WESTMEAD CATHOLIC COMMUNITY EDUCATION CAMPUS APPENDIX A - RESPONSE TO SUBMISSIONS AND REQUEST FOR ADDITIONAL INFORMATION AND CLARIFICATIONS

19122	K6-DA-906	D
project_no.	sheet_no.	issue

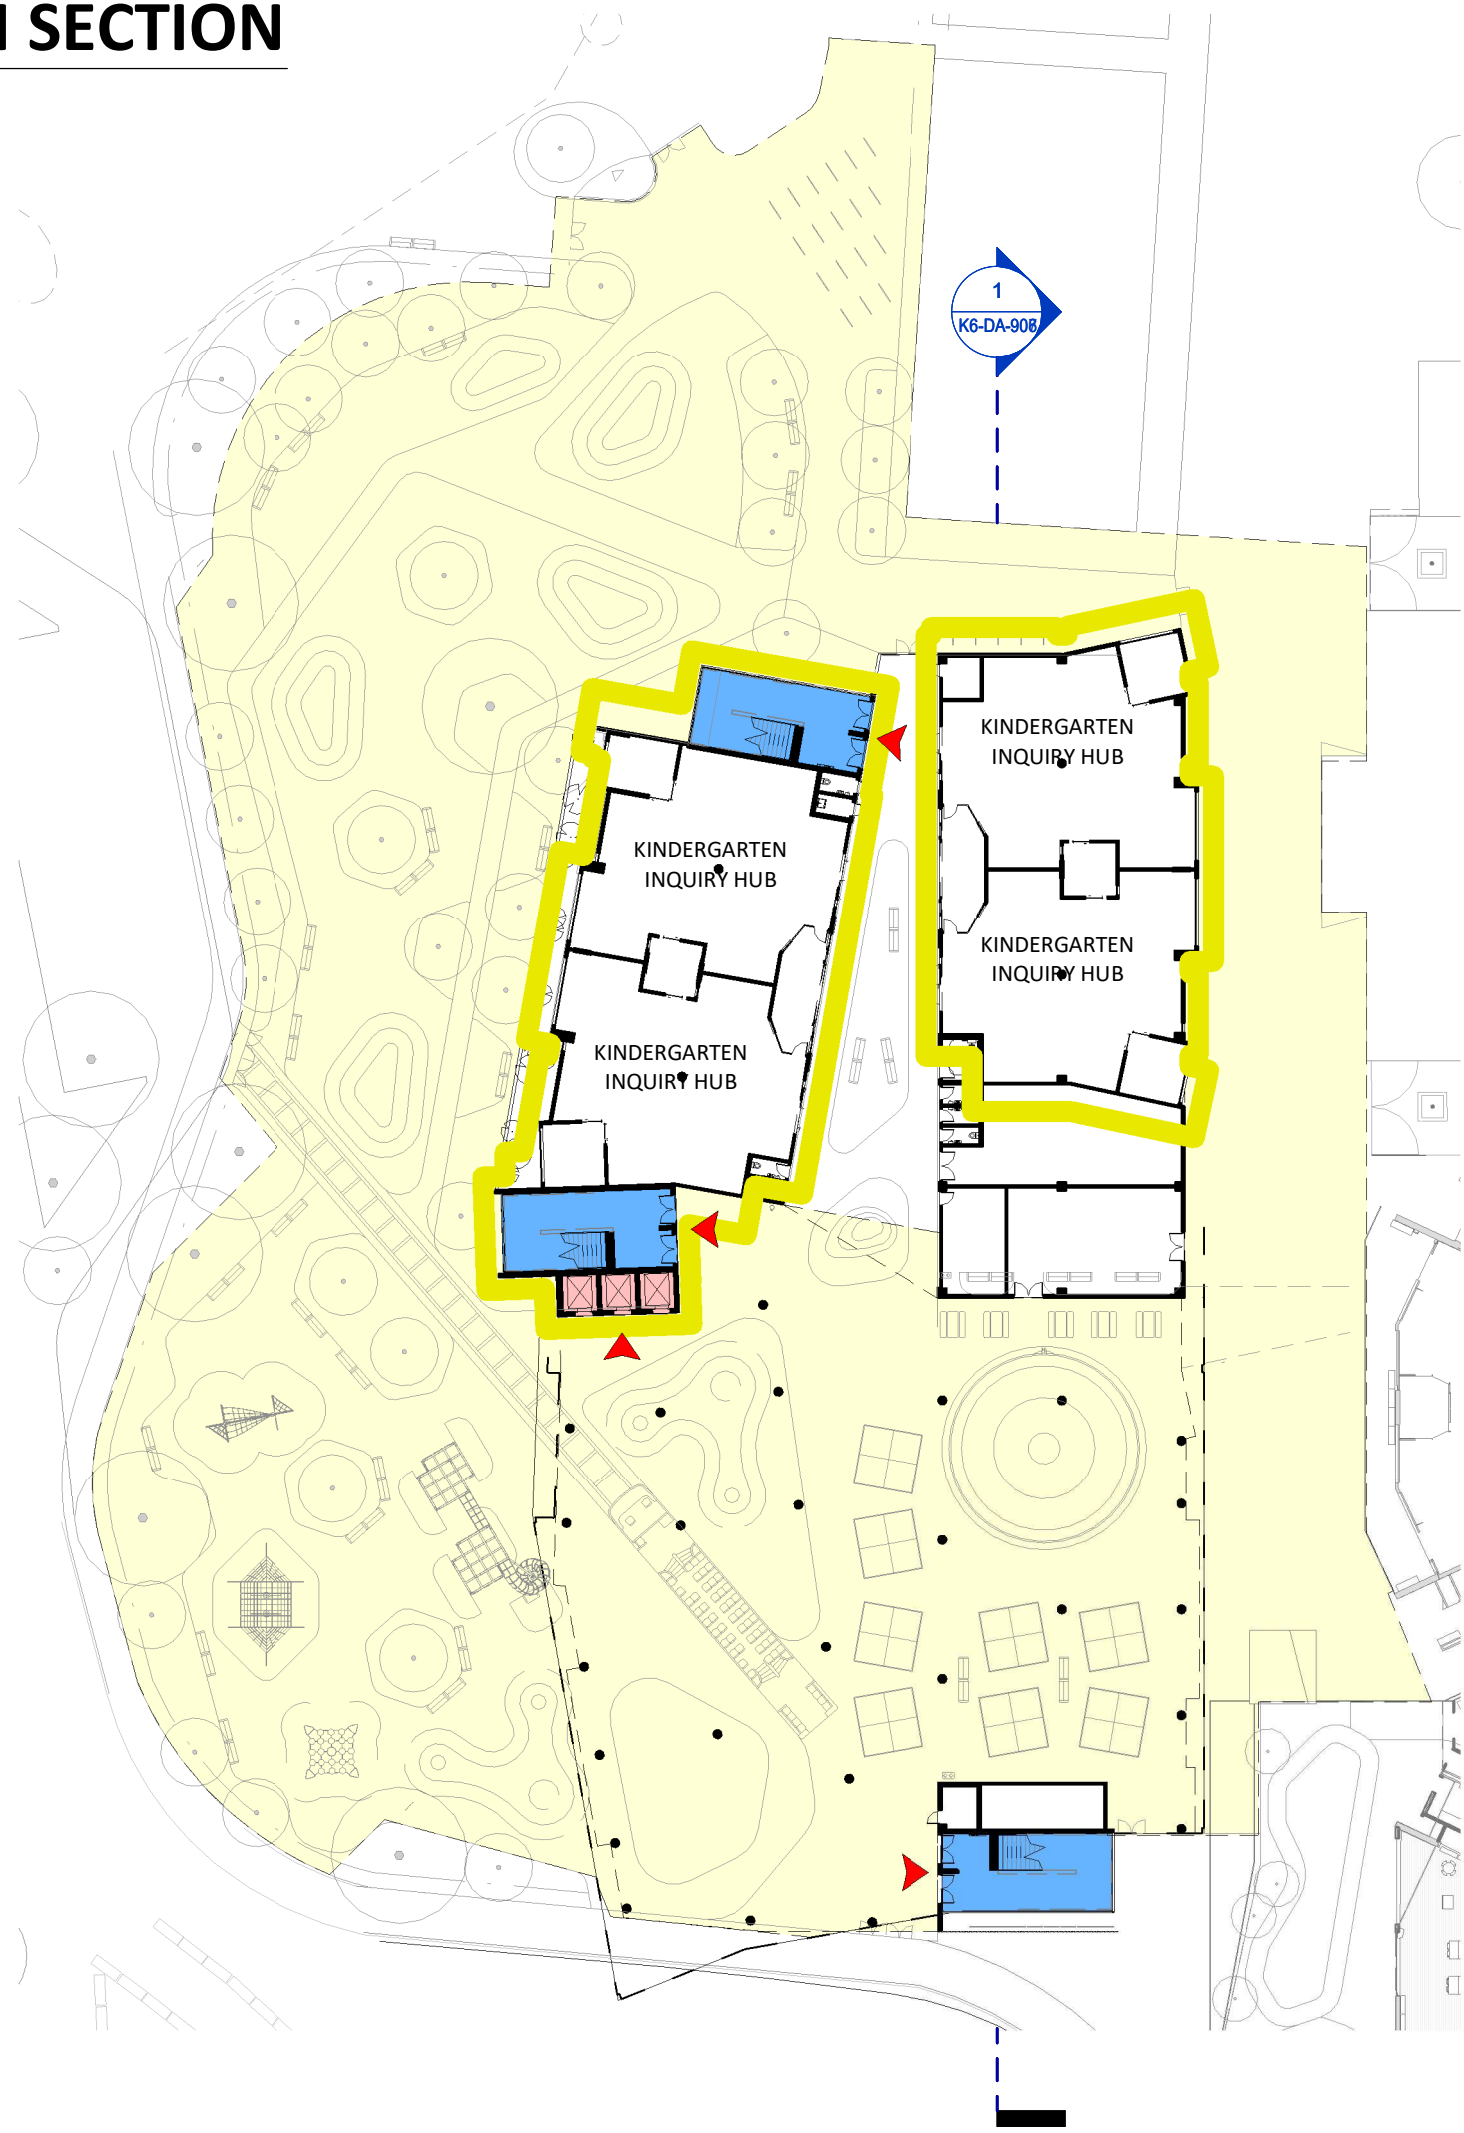
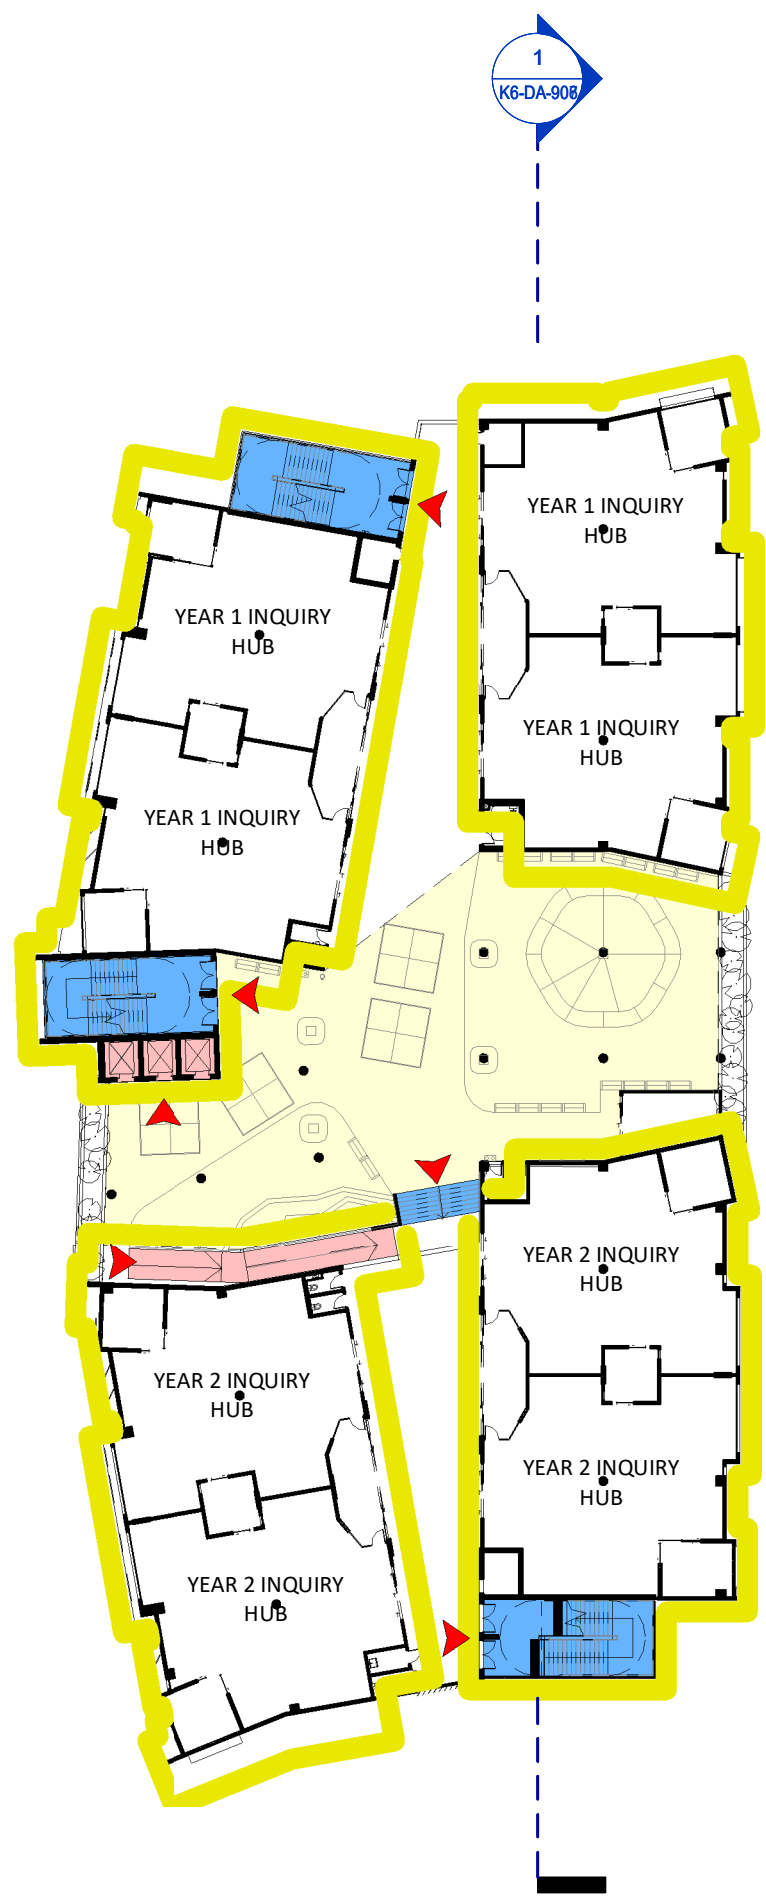
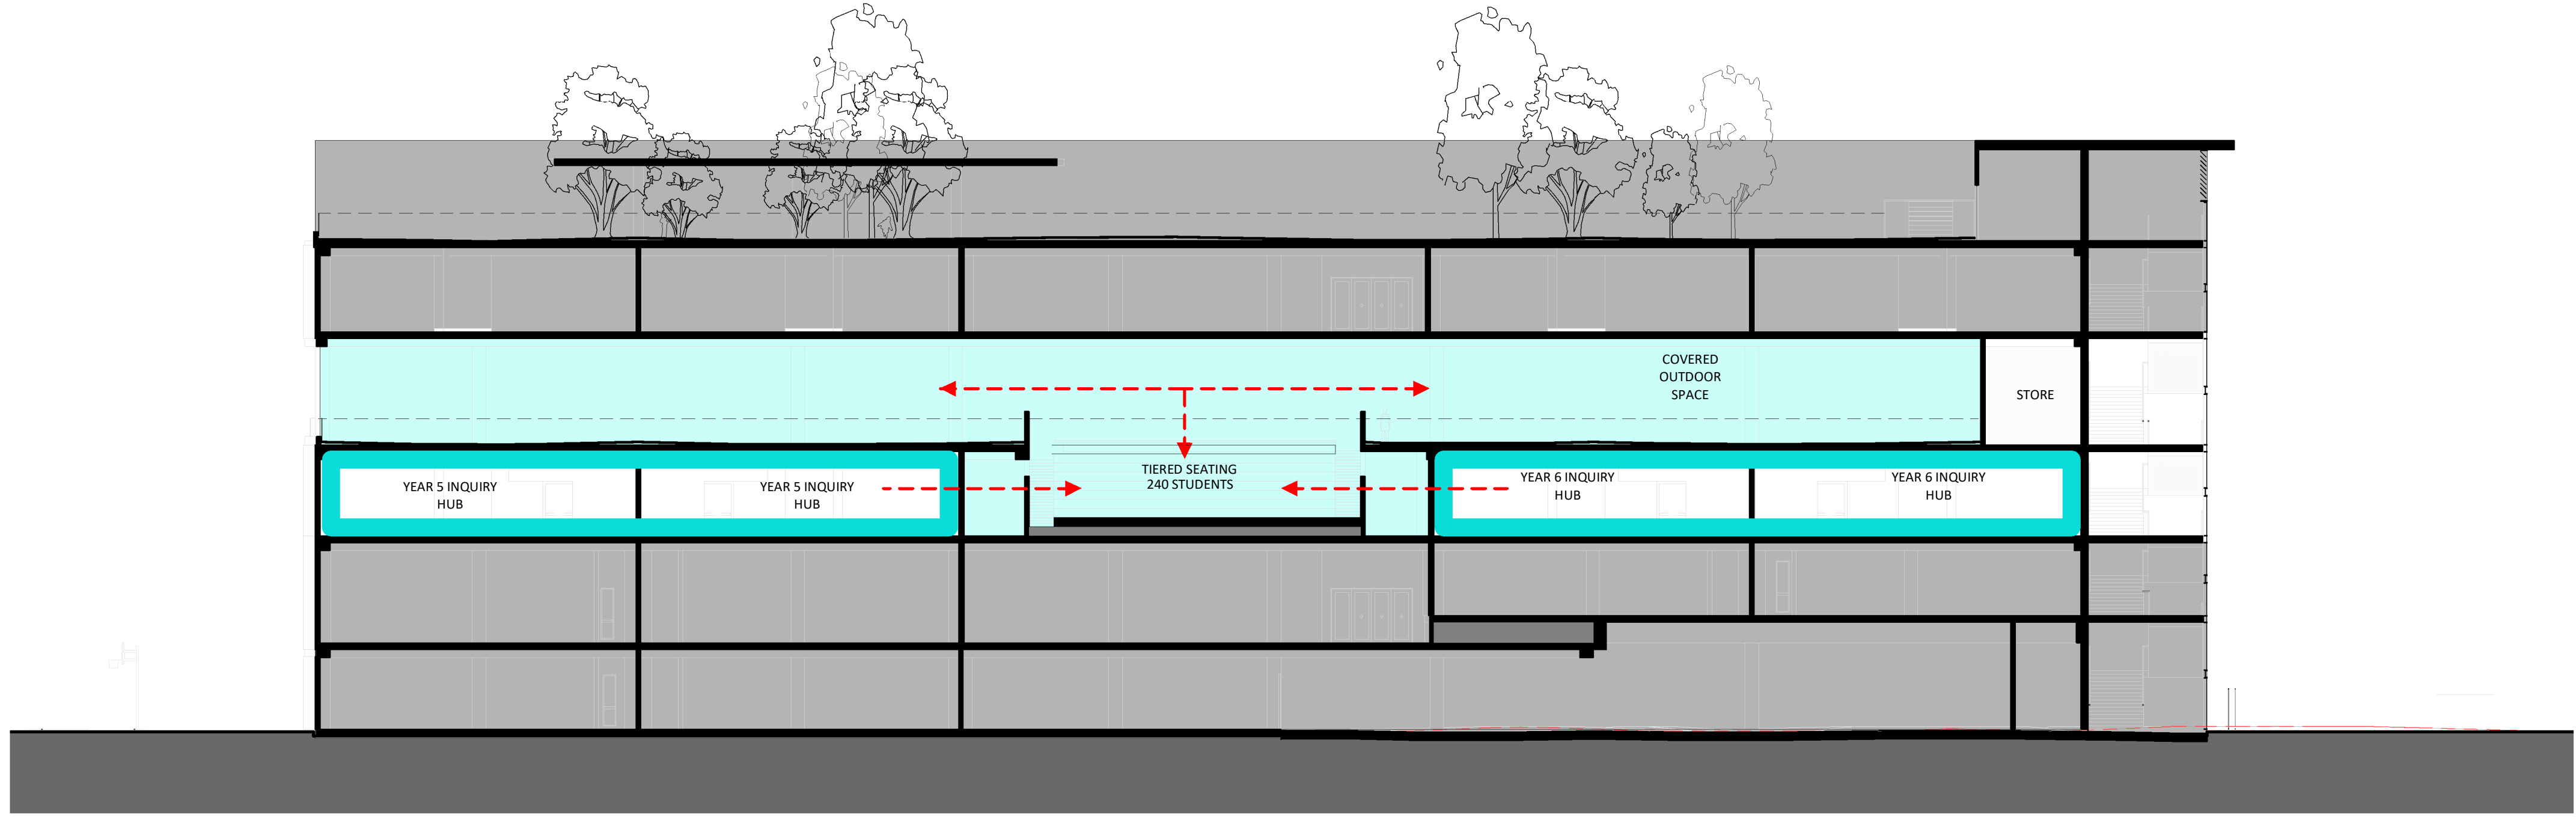
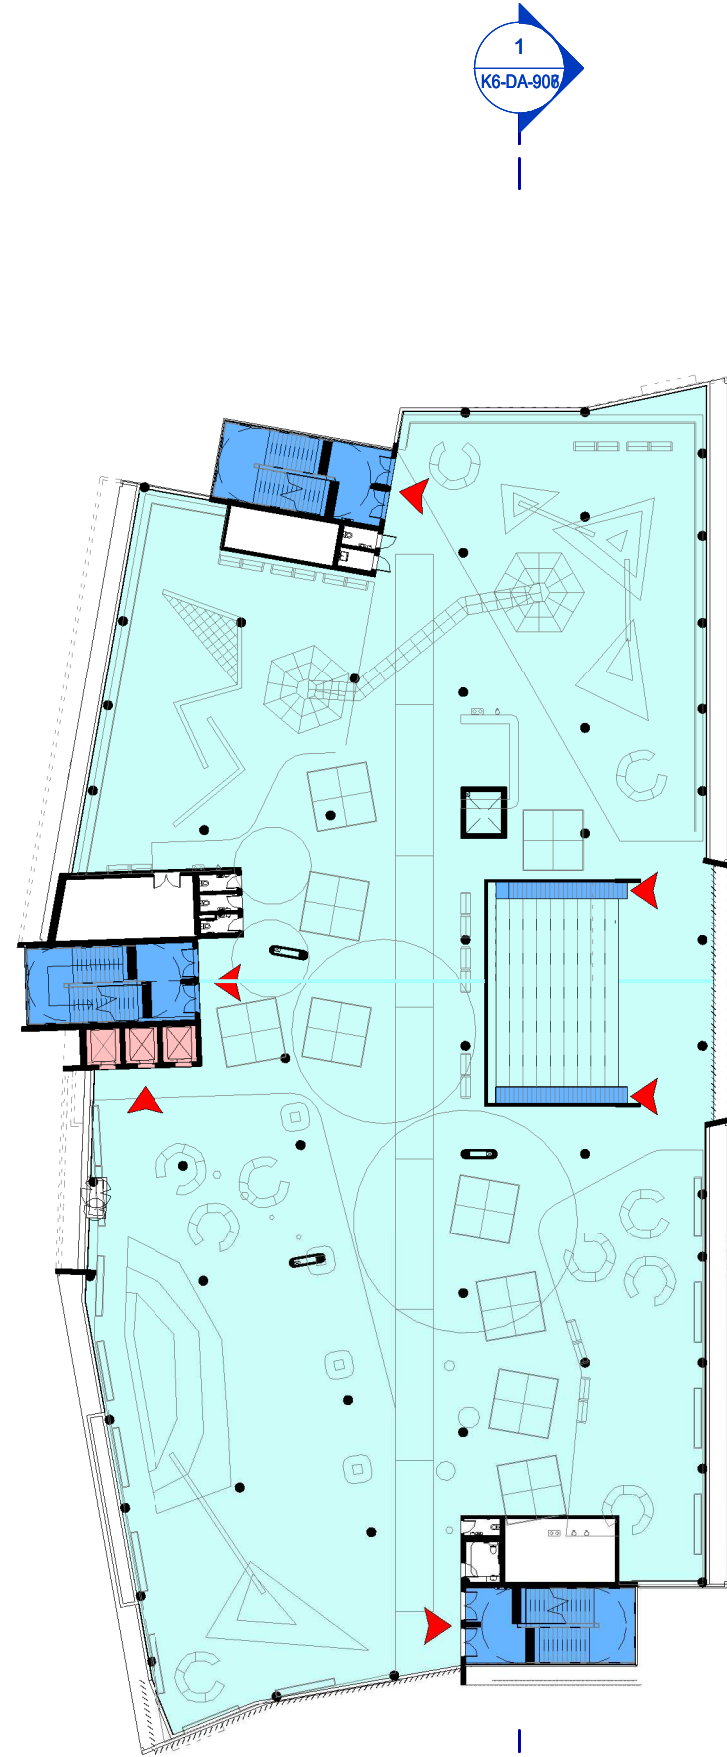
3			<p>No details have been provided regarding the solar access / daylight access provisions to the upper level open spaces. Given the nature and design of the open spaces, it is likely that these areas would not receive sufficient sunlight (in excess of three hours) during the winter solstice.</p>	<p>A Solar and Access Daylight Analysis has been prepared by Erbas Sustain (Appendix O). The design of the building seeks to achieve a balance between providing shade for comfort and sun protection in Summer, and solar access for warmth and light in Winter.</p> <p>With respect to solar access, the analysis finds that:</p> <ul style="list-style-type: none"> All outdoor play areas at Ground, Levels 1 - 5 received ≥ 3 hours of direct solar access on the Winter Solstice. On the Summer Solstice, all outdoor play areas at Ground and Levels 1 - 4 are generally well-shaded from direct solar access, with coverage ranging from 55% to 100%. While most of Level 5 is unshaded, parts of the Level 5 outdoor play area remain shaded on the Summer Solstice for sun protection. <p>With respect to daylight, the design has been benchmarked against various Councils' lighting policies and AS1158.3.1:2005 Lighting for Roads & Public Spaces. The National Construction Code on natural lighting and AS1680.2 are intended for interior spaces rather than outdoor areas, and so have not been used as a benchmark in this instance.</p> <p>The design aims to achieve at least 50 lux without lighting (as required under the Standards, and to be supplemented with artificial lighting) to most of the main outdoor play area at Ground Level, Level 3 and Level 5, and at least 21 lux to the passive/secondary play areas Level 1, Level 2 and Level 4. For reference, 50 lux is a desirable lux indicated in AS2560.2.3-2007 for sports field recreation and physical training. 21 lux is considered a mid-range lux and the highest level of illuminance for public activity areas as indicated in AS1158.3.1:2005.</p> <p>The analysis finds that, on average, 72% -89% of the outdoor play areas achieve an annual average of > 50 lux during the indicative operational hours (8:00am –6:00pm) throughout the year. Overall, daylighting to an average of at least 80% of the outdoor play areas is sufficient for the level of activities equivalent to a public playground. Where required, artificial lighting will be used to complement natural lighting for visual comfort.</p>
